November 14, 2022

JN 22008

Subject: **Review of Plans**
Proposed New Residence
2448 – 72nd Avenue Southeast
Mercer Island, Washington

**ROOF/FOOTING DRAIN DETAIL**  
NO SCALE

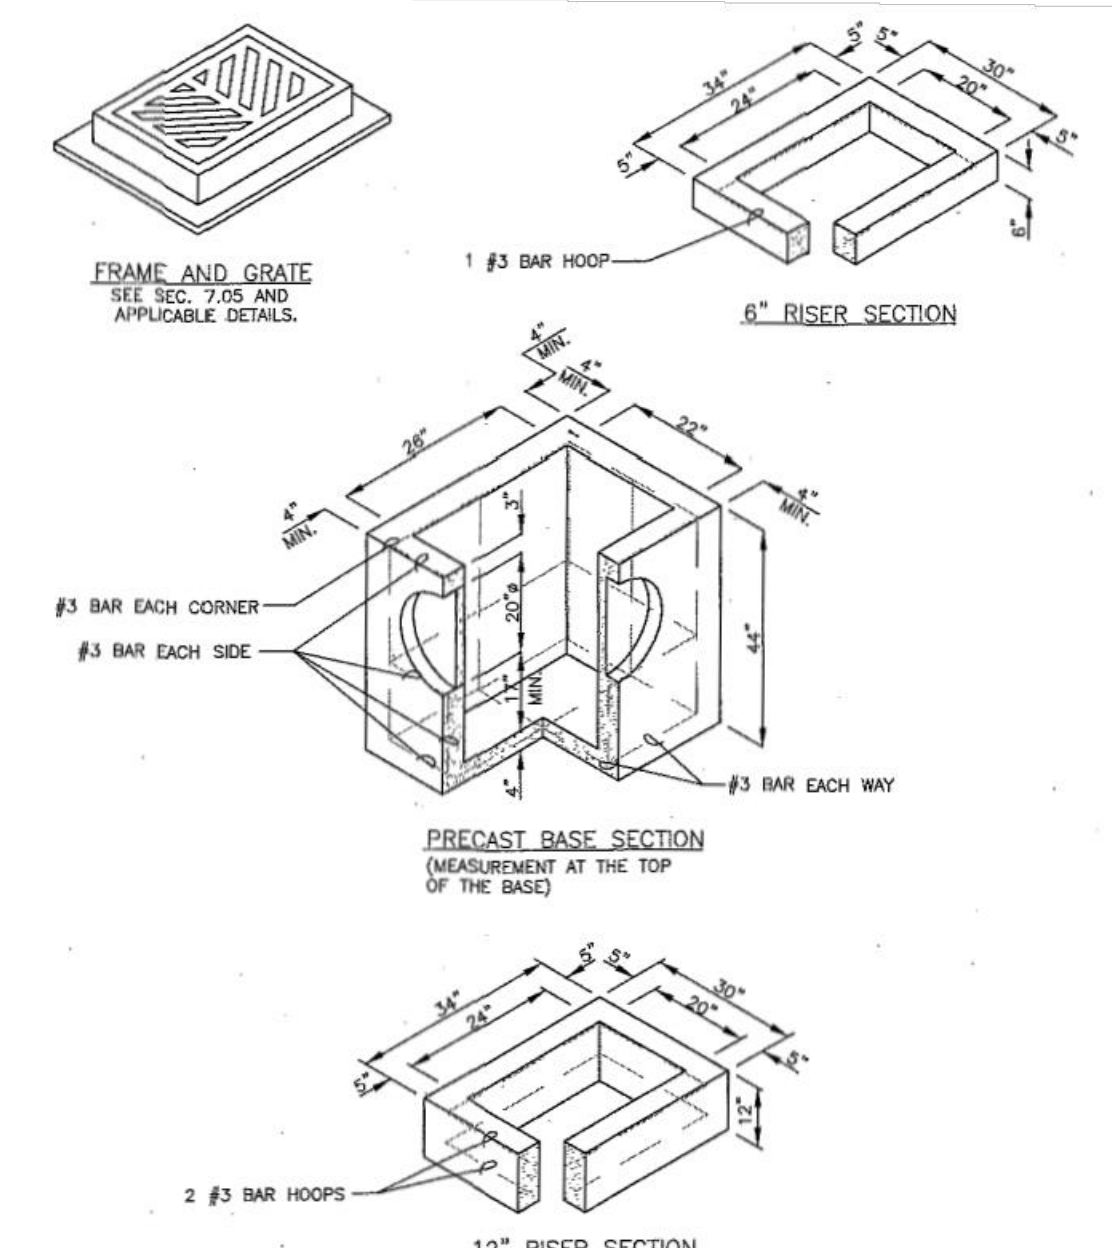
These measures are intended to prevent standing water from accumulating on top of the vapor retarder. These comments are incorporated into the Roof/Footing Drain Detail by Encompass Engineering and Design on page 5 of their drawings.

1 FOUNDATION DETAIL - TYP
SCALE: 3/4" = 1'-0"

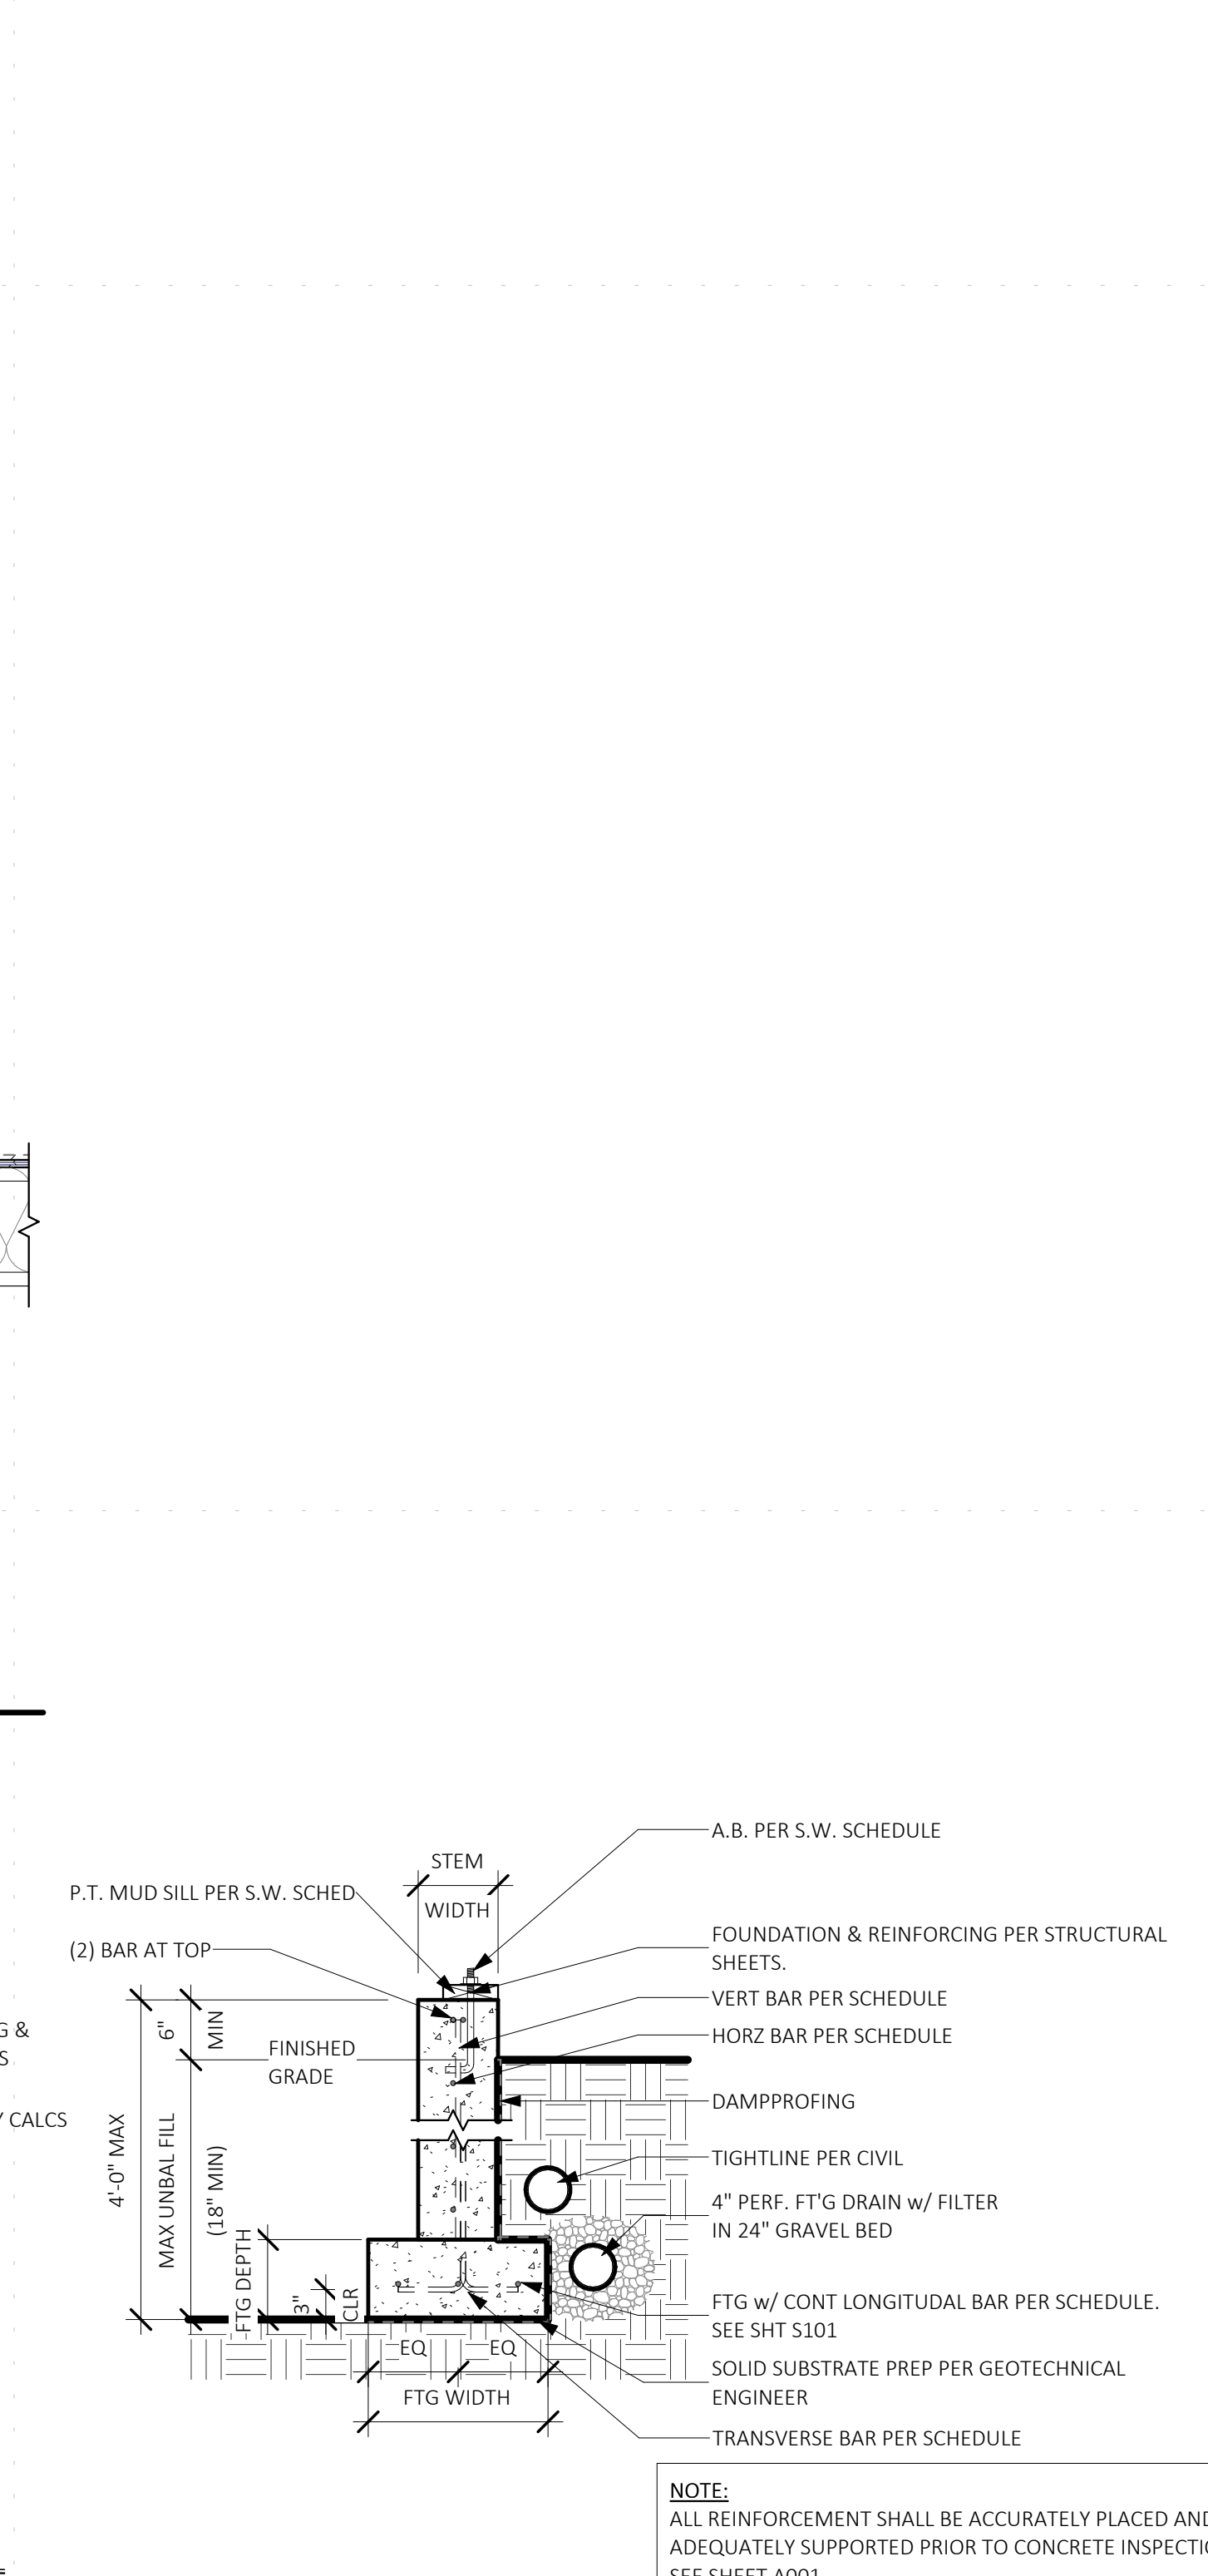
As expected, the amount of excavation for the new house will be limited to that necessary for the foundations and the crawl space. Detail 1/D101 shows the footing drain to be located above the ground surface in the crawl space. Due to the low permeability of the underlying soil, it will be important to:

1. Set the invert elevation of the perimeter footing drains at, or below, the level of the interior crawl space, and
2. Place several inches of clean gravel underneath the vapor retarder, with an outlet drain.
